From: Amanda Scholes on behalf of Planning.Responses
Sent: 19 September 2019 12:53
To: Planning Scanning
Subject: FW: Planning Consultation on: A/122/19/OUT

Engineers Comments Regarding Surface Water Drainage

APPLICATION NO: A/122/19/OUT

Site Address: Land off Arundel Road Angmering BN16 4ET

Figure 5.3: Land Use Plan.

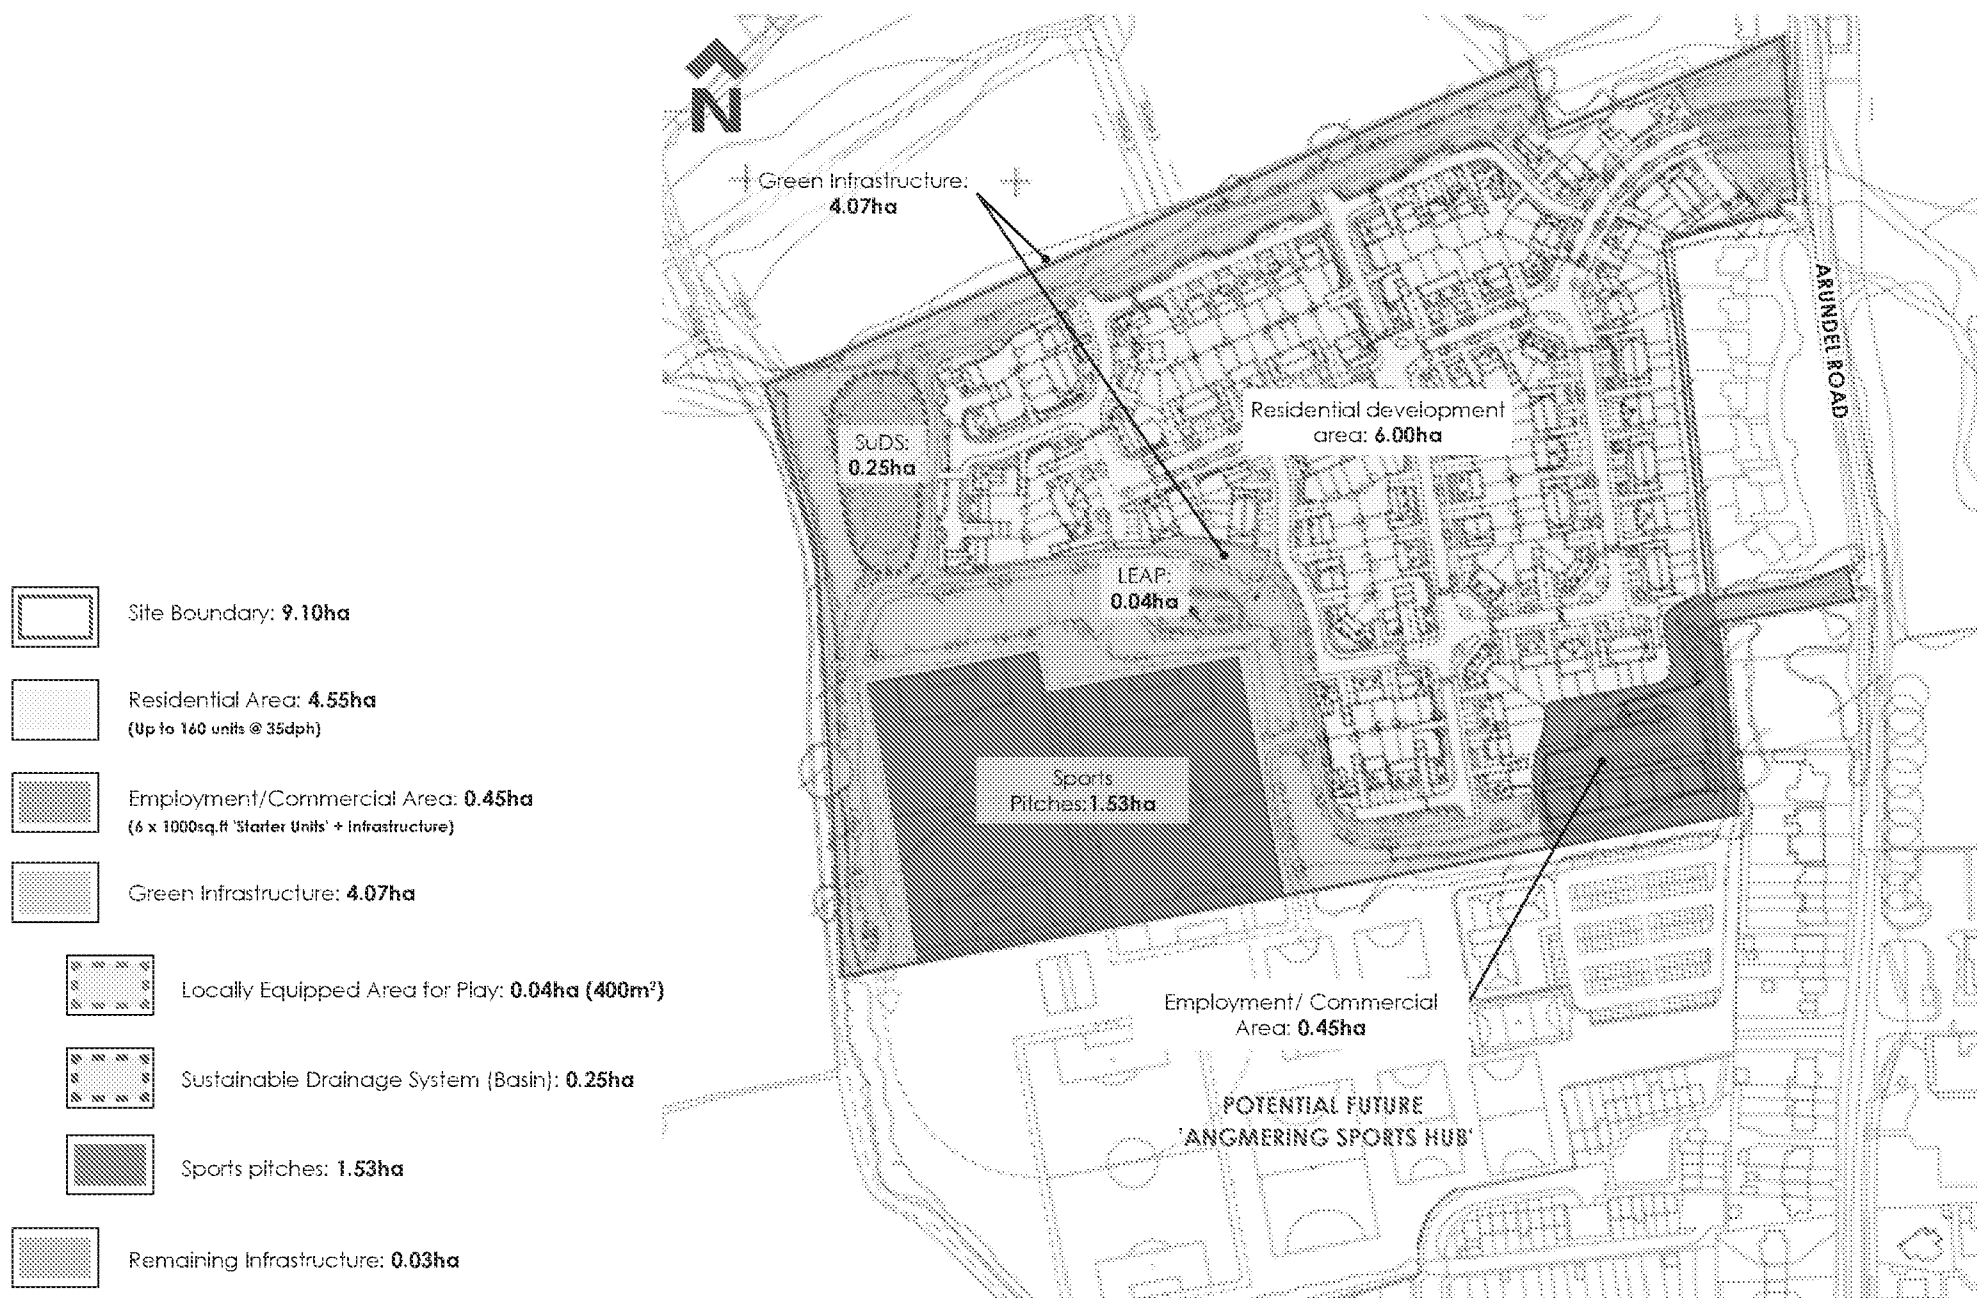
High level calculations have been provided for the basin sizing's, however it is not clear in these calculations what impermeable area has been modelled. It is therefore not possible for us to establish if the proposed basin size would be adequate should it be found that infiltration is not feasible.
